The following is a list of the EPC conditions from 12/25. Please see the below notes and attachments, I believe they address all your requests. I look forward to hearing your feedback.

CONDITIONS OF APPROVAL Project #: SP-2025-00091, a Site Plan – EPC, Major Amendment

DRAWN BY: JRM	336 Woodward Road SE
CHECKED BY:	
SCALE: AS NOTED	TITLE: TYPICAL 8'-0" H FENCE ELEVATION AND DETAILS
DATE: 11/20/2025	SHEET NO: SK001

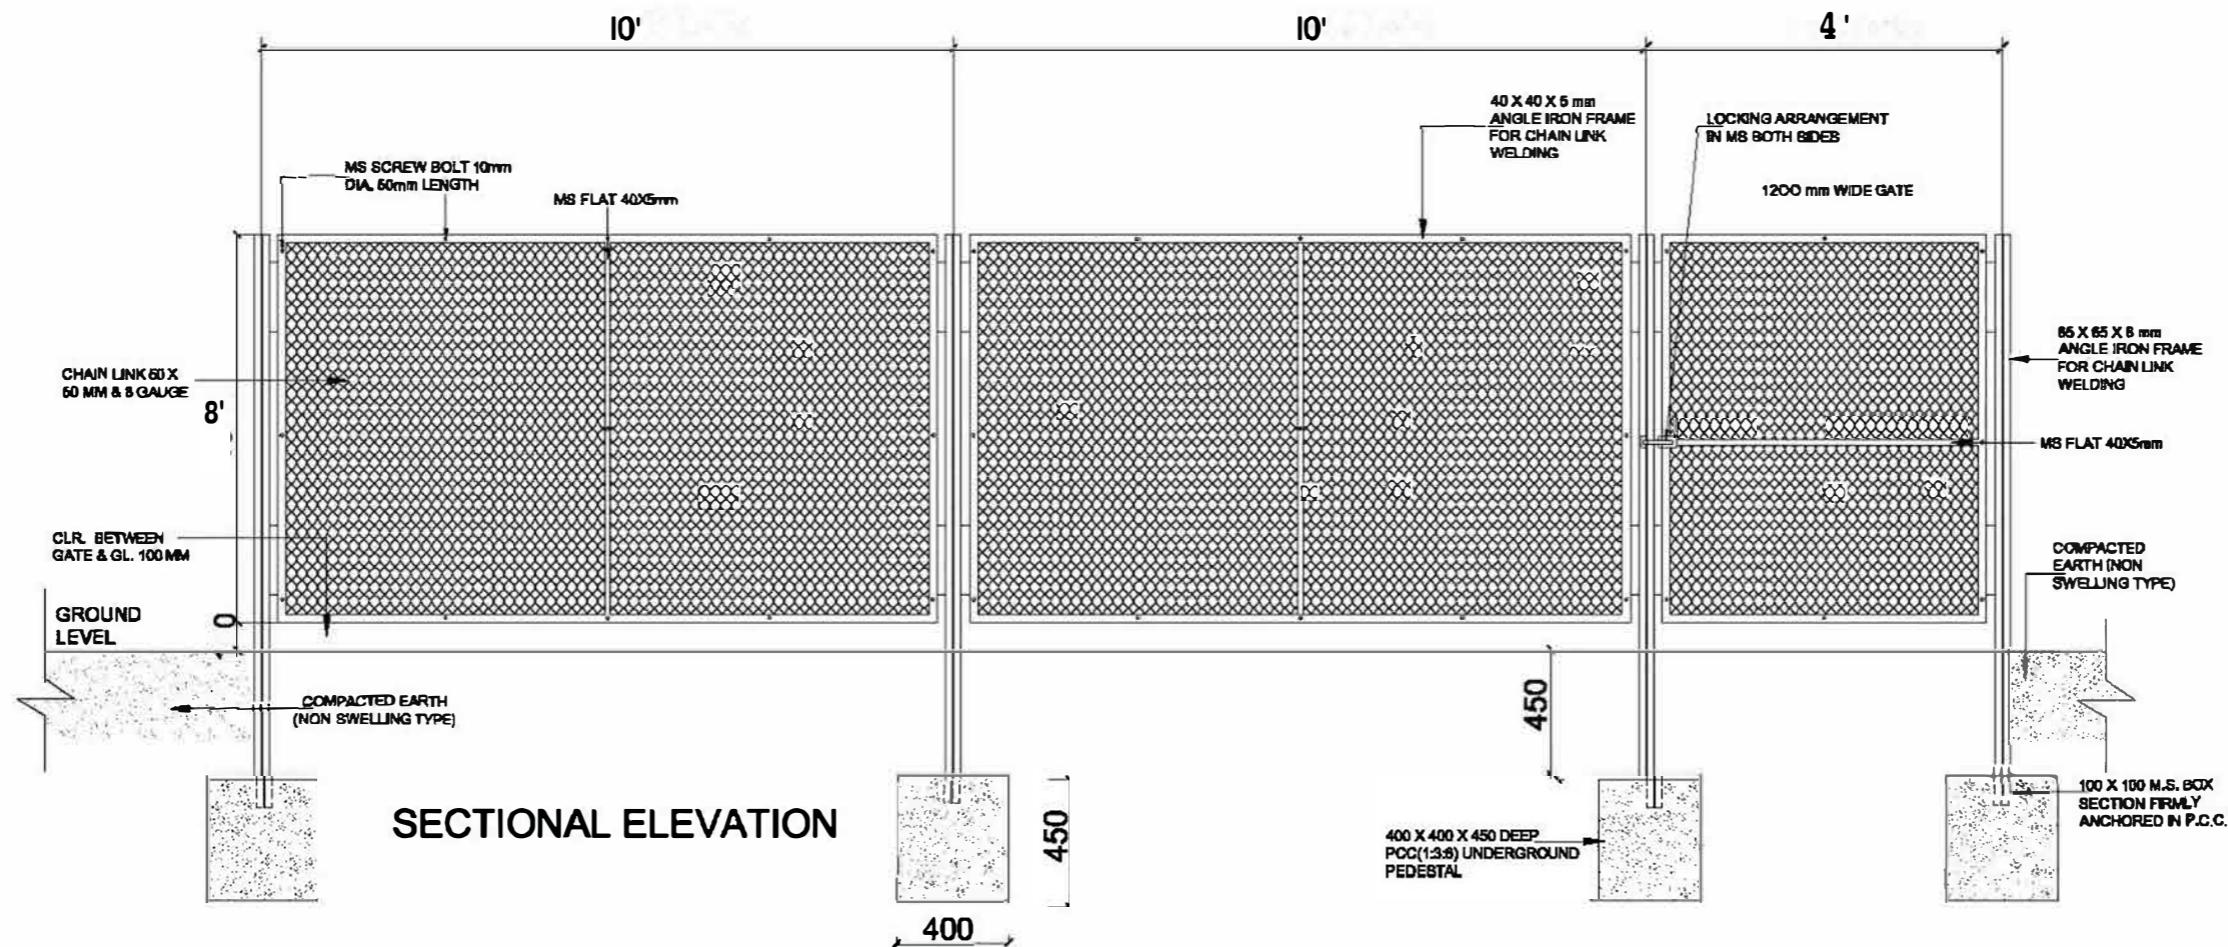
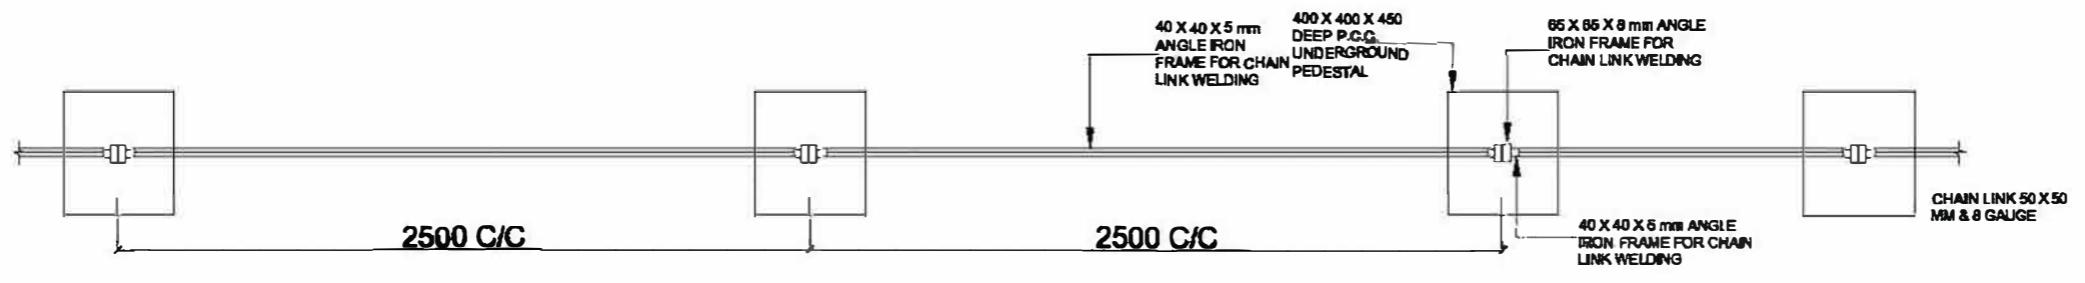
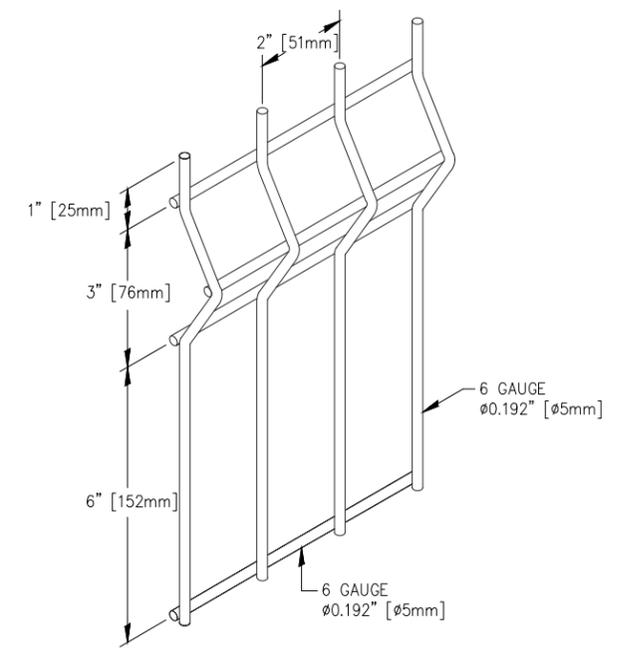
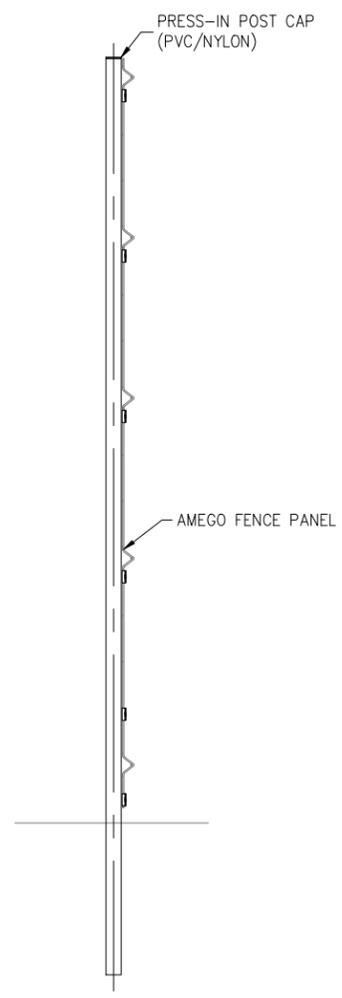
- 1. All walls and fences (internal and around perimeter) shall be shown on the site plan. OK**
- 2. All walls and fence detail shall be shown on a detail sheet for each that provides height, type/material, and any screening materials (e.g., fabric, slats). OK... detail sheets provided and lots of notes on the main site plan as well**
